East Anglia ONE North and East Anglia TWO Offshore Windfarms

Applicants' Comments on Marine Management Organisation's Deadline 10 Submissions

Applicant: East Anglia TWO and East Anglia ONE North Limited
Document Reference: ExA.AS-7.D11.V1
SPR Reference: EA1N_EA2-DWF-ENV-REP-IBR-001075

Date: 7th June 2021
Revision: Version 01
Author: Royal HaskoningDHV

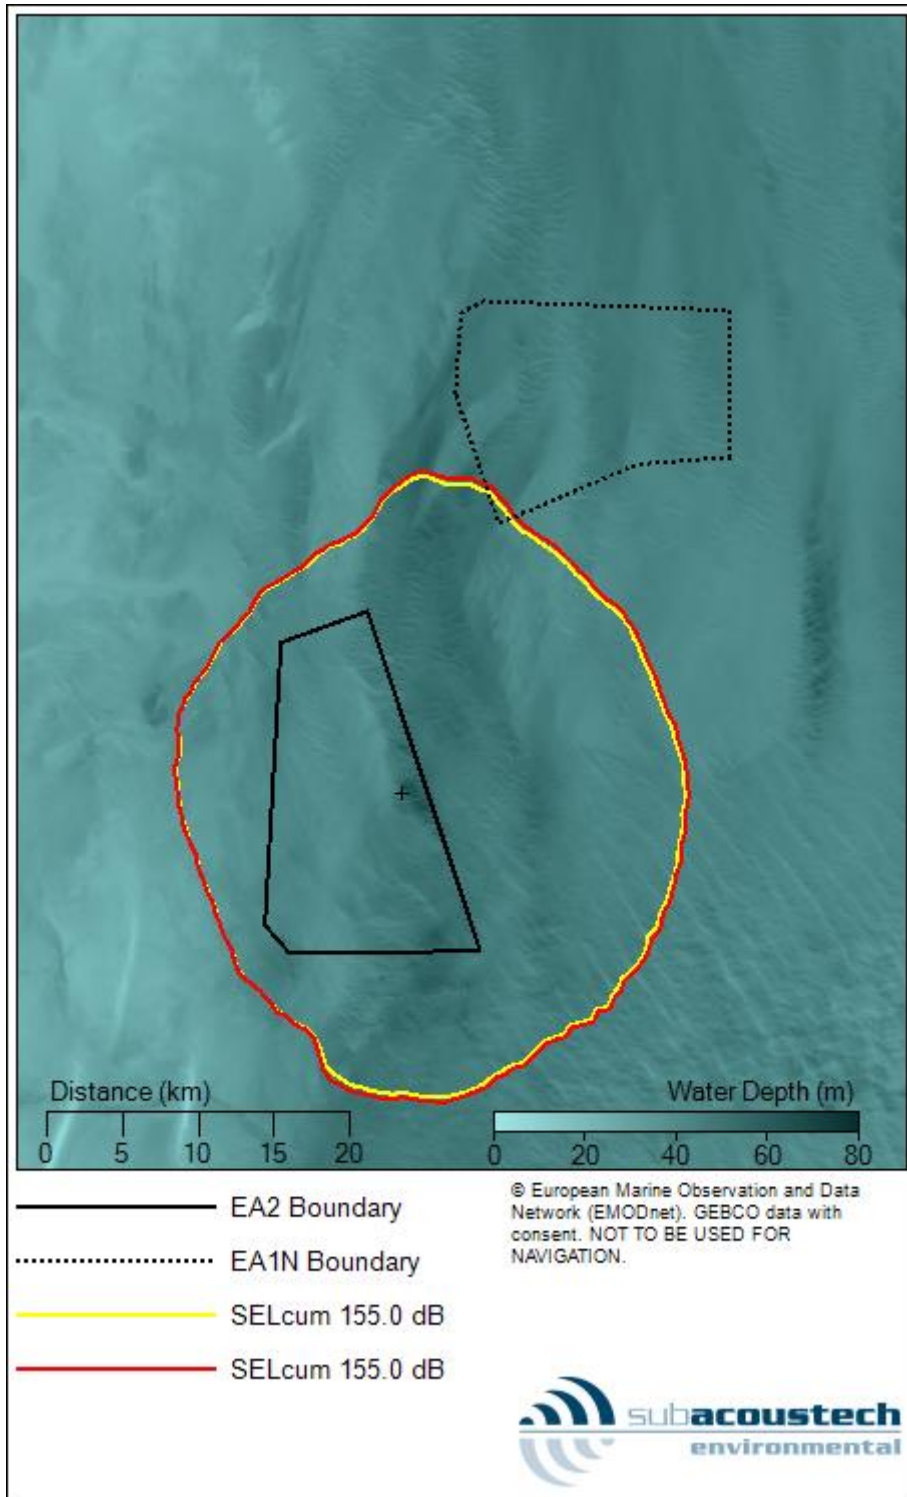
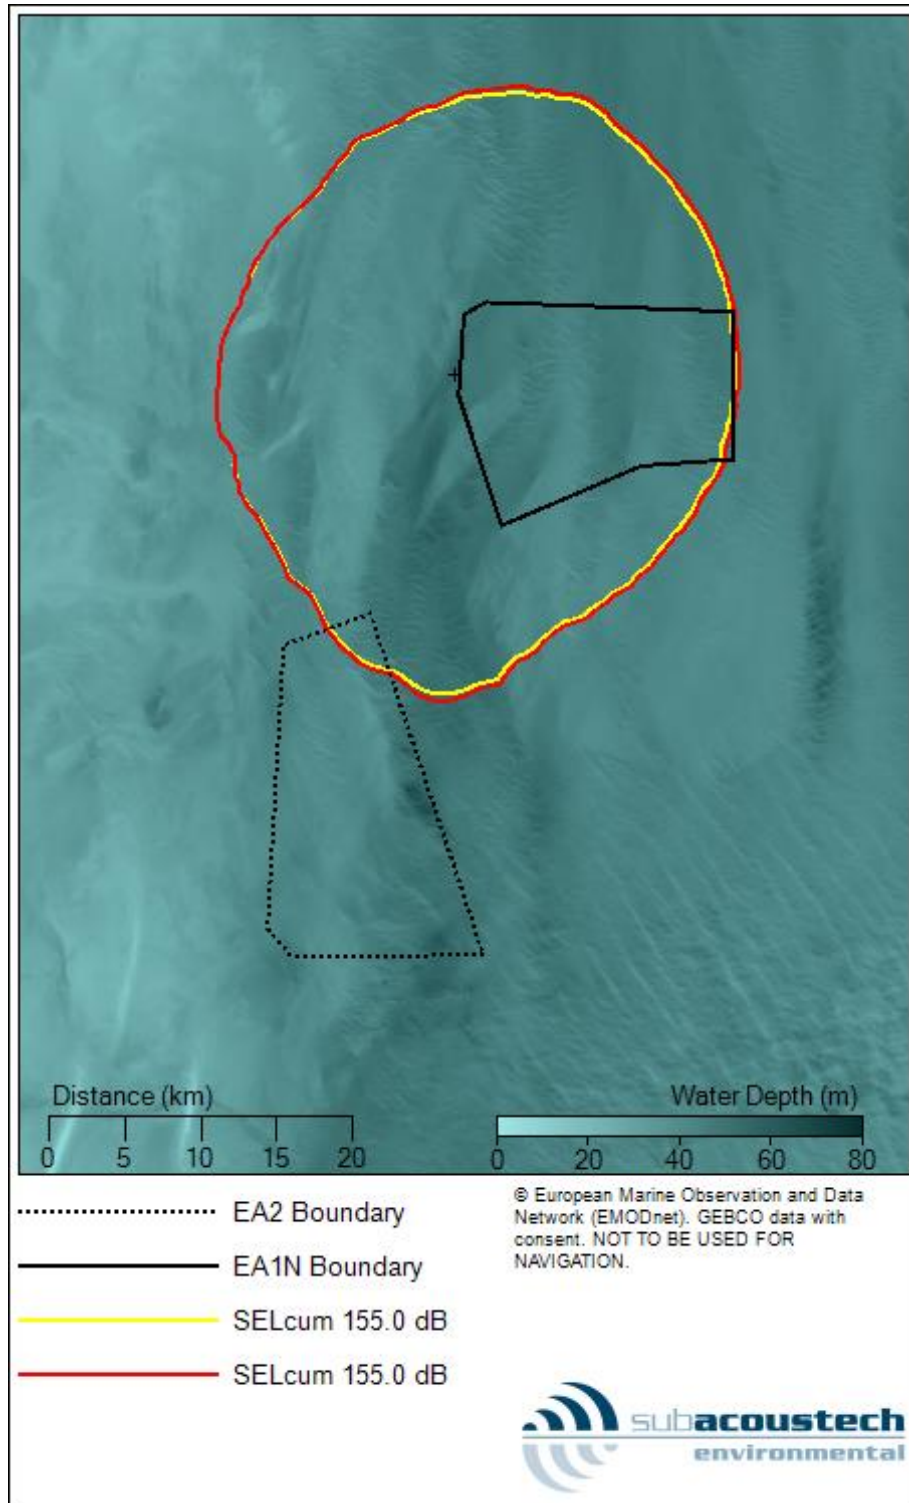
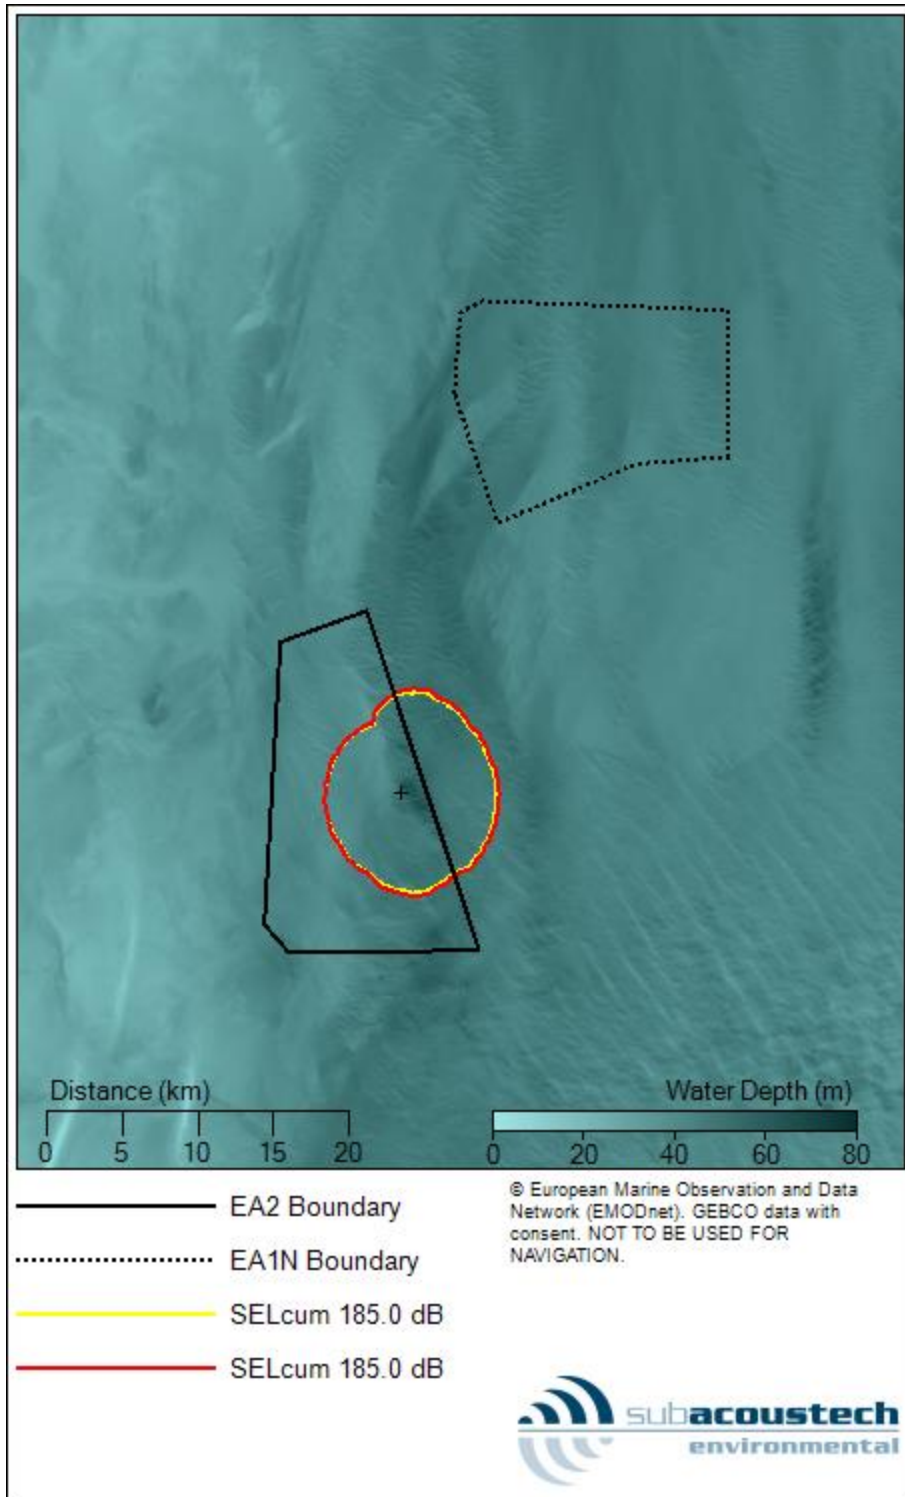
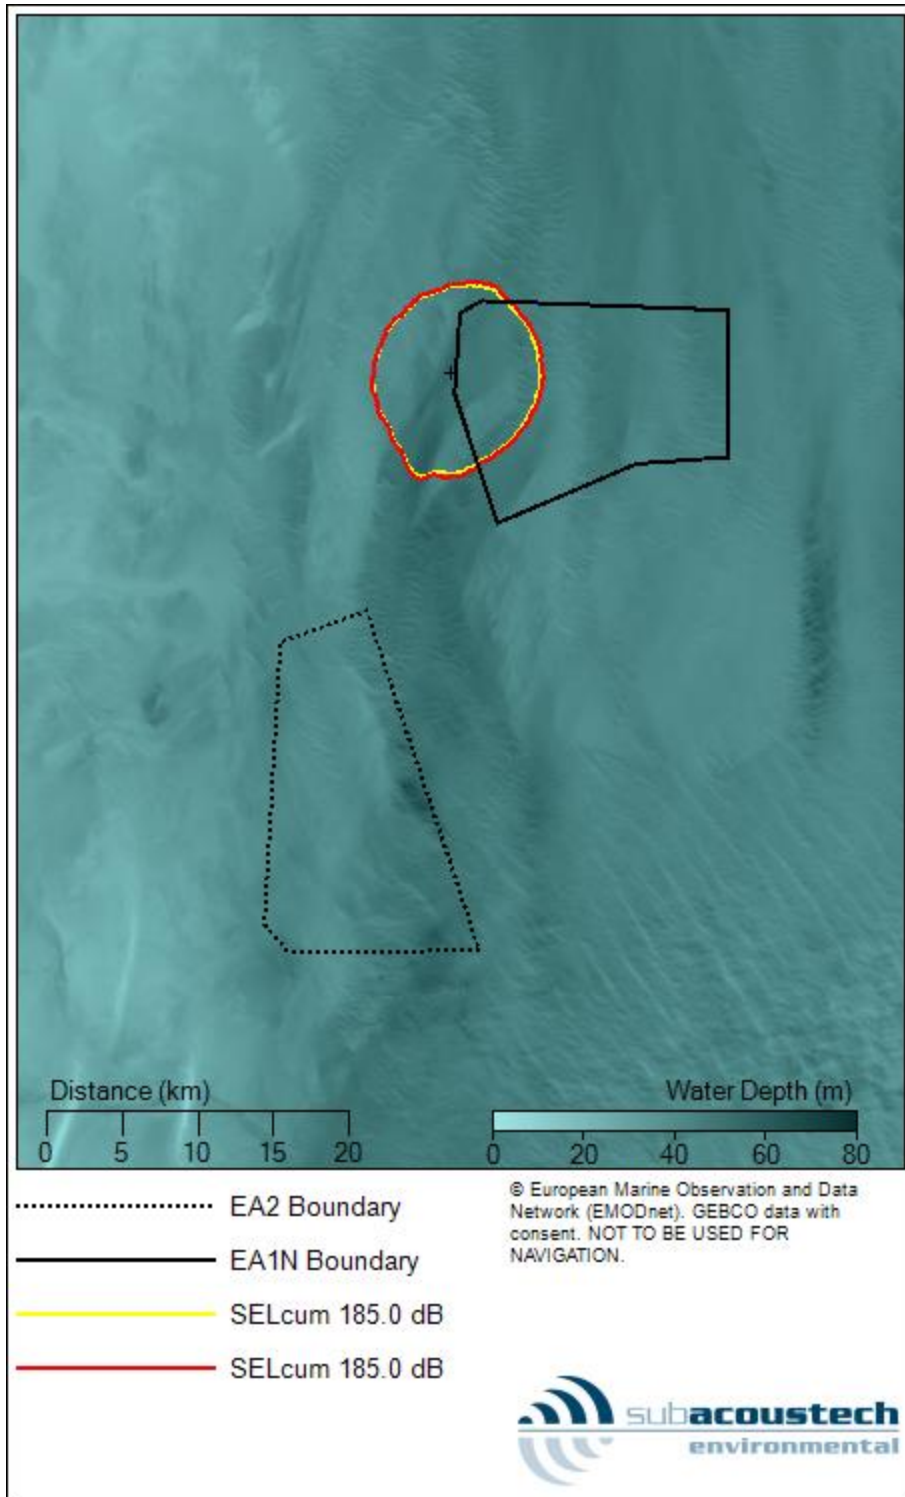
ID	MMO Comment / Section of MMO Response Considered	Applicants' Comments
1. Underwater Noise Update		
1	<p>1.1 Sequential Piling</p> <p>The MMO set out in its Deadline 9 response [REP9-021] that it was not content that the Applicant has adequately assessed the risk of installing more than one monopile in a 24-hour period in their Underwater Noise Update [REP8-040] submitted at Deadline 8, this concern centred around the fact that the monopiles will likely be installed at different locations.</p> <p>The Applicants provided the modelling to the MMO and Cefas following a workshop on 13th April. The MMO are engaging with the Applicants regarding the updated REP8-040 with the aim of reaching agreement by Deadline 11. The MMO will continue discussions with the Applicant on this matter.</p>	<p>The Applicants have been engaging with the MMO on this matter and have now reached agreement on the underwater noise modelling report which has been submitted at Deadline 11 (document reference ExA.AS-5.D11.V2).</p>
